9th October 2019

Single storey rear extension, new timber boarding & fenestration changes & minor internal alterations. This application affects the character & appearance of the Arundel Conservation Area.

30 High Street Arundel

Ground Floor Plan 1:100

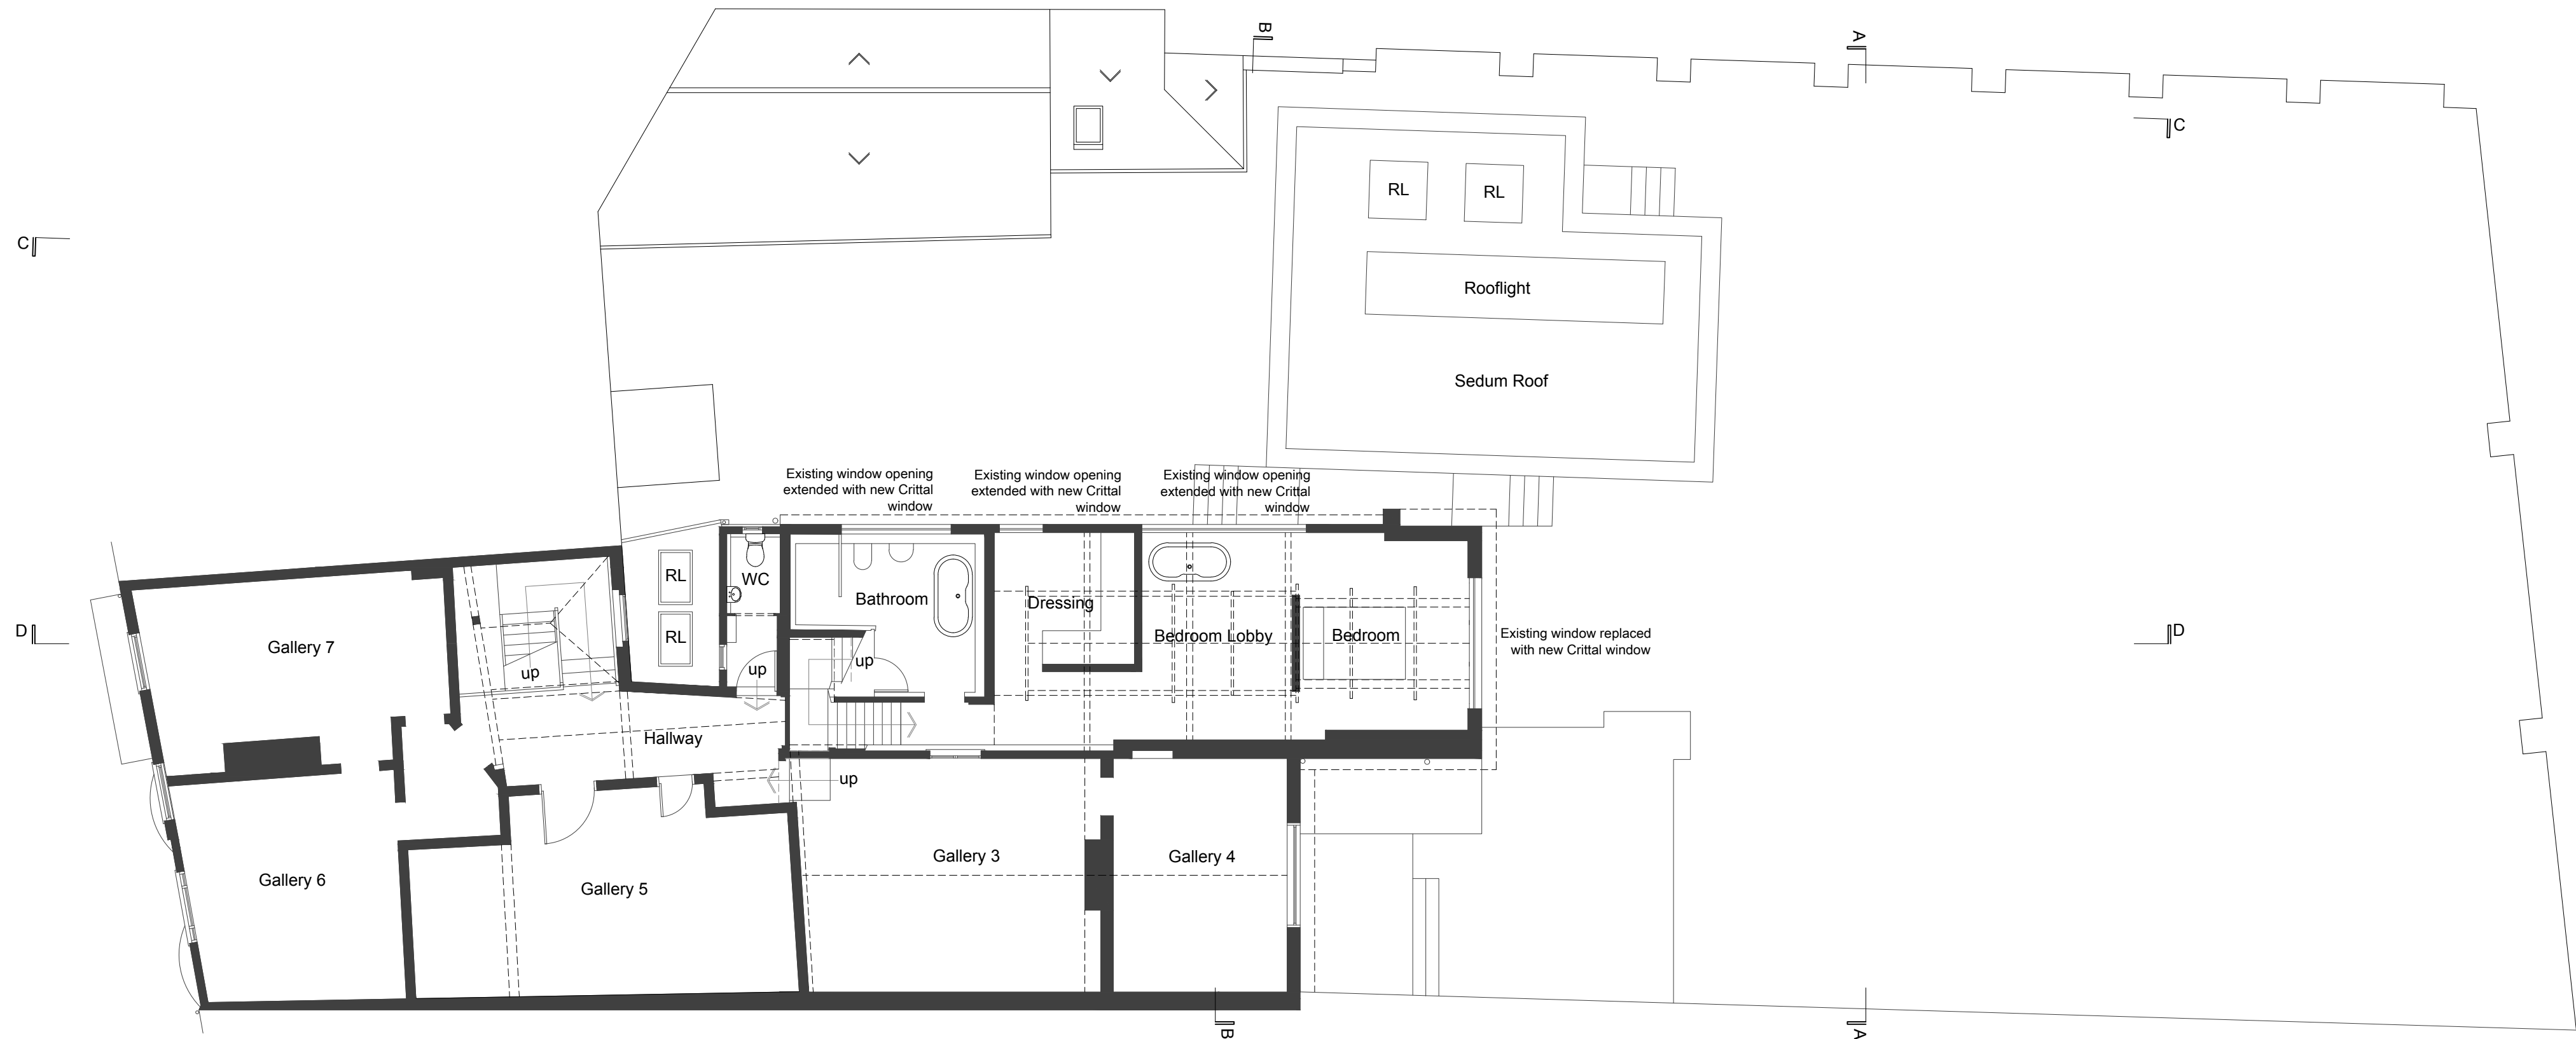
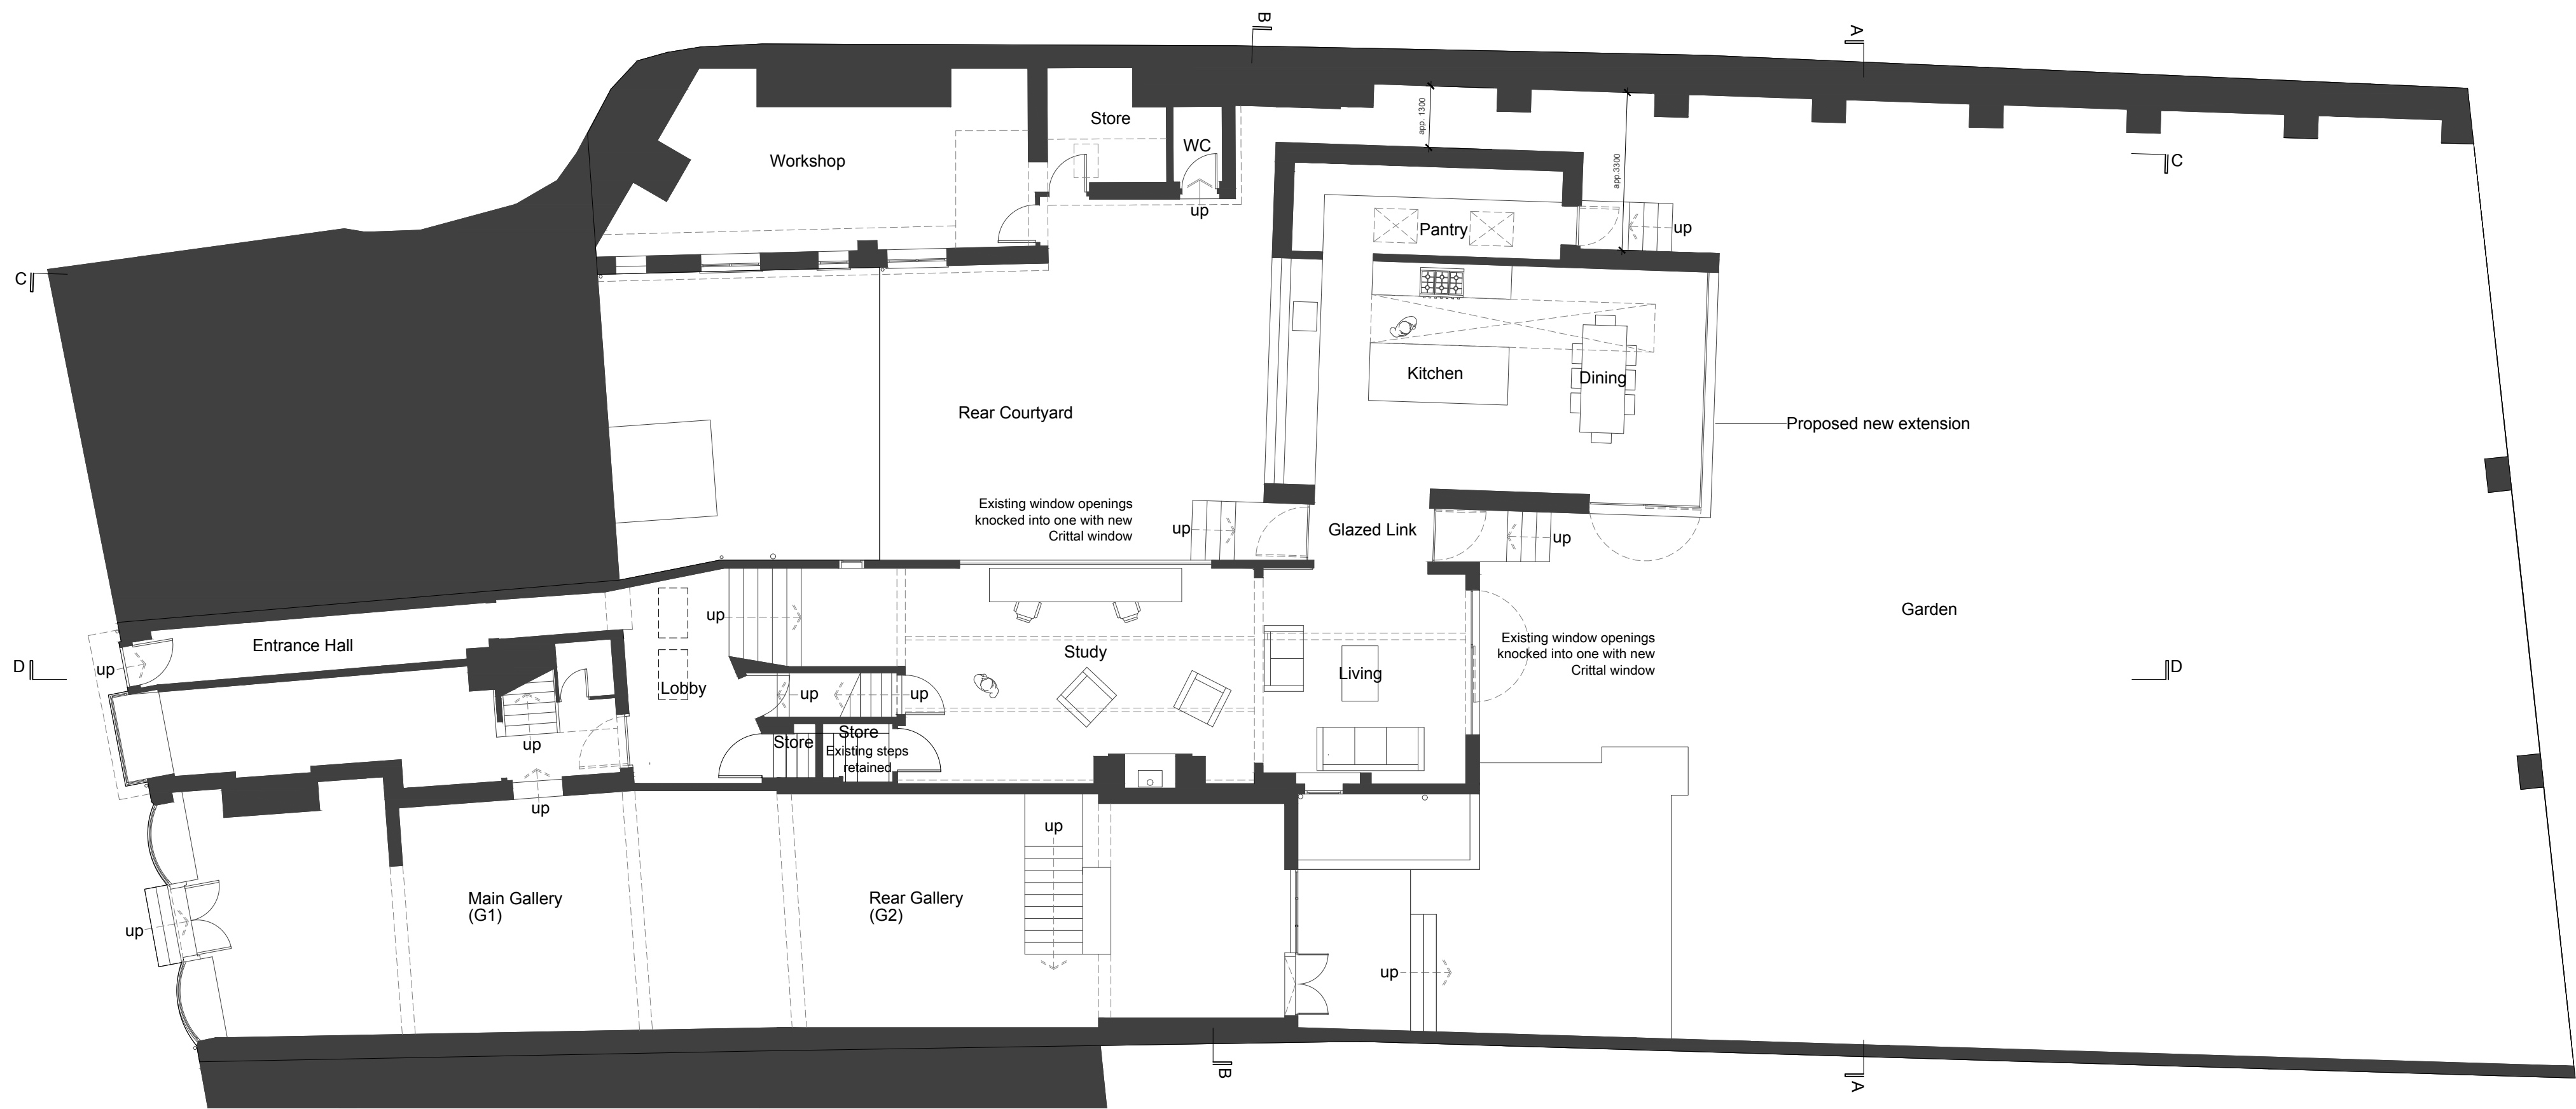
The proposed extension is of a simple modern design and is of a scale and height which does not impact adversely on the existing building. It is important that it should be of high quality detailing and materials; if so, then its modern design will complement and add to the long historic building evolution of the premises.

If the Council is minded to grant permission it is suggested that conditions be attached requiring the submission of precise details of materials, finishes and fenestration. Perhaps a detail also needs to be submitted of the junction of the external walls with the roof of the proposed extension to ensure a finish and appearance appropriate to the modern design of the structure.
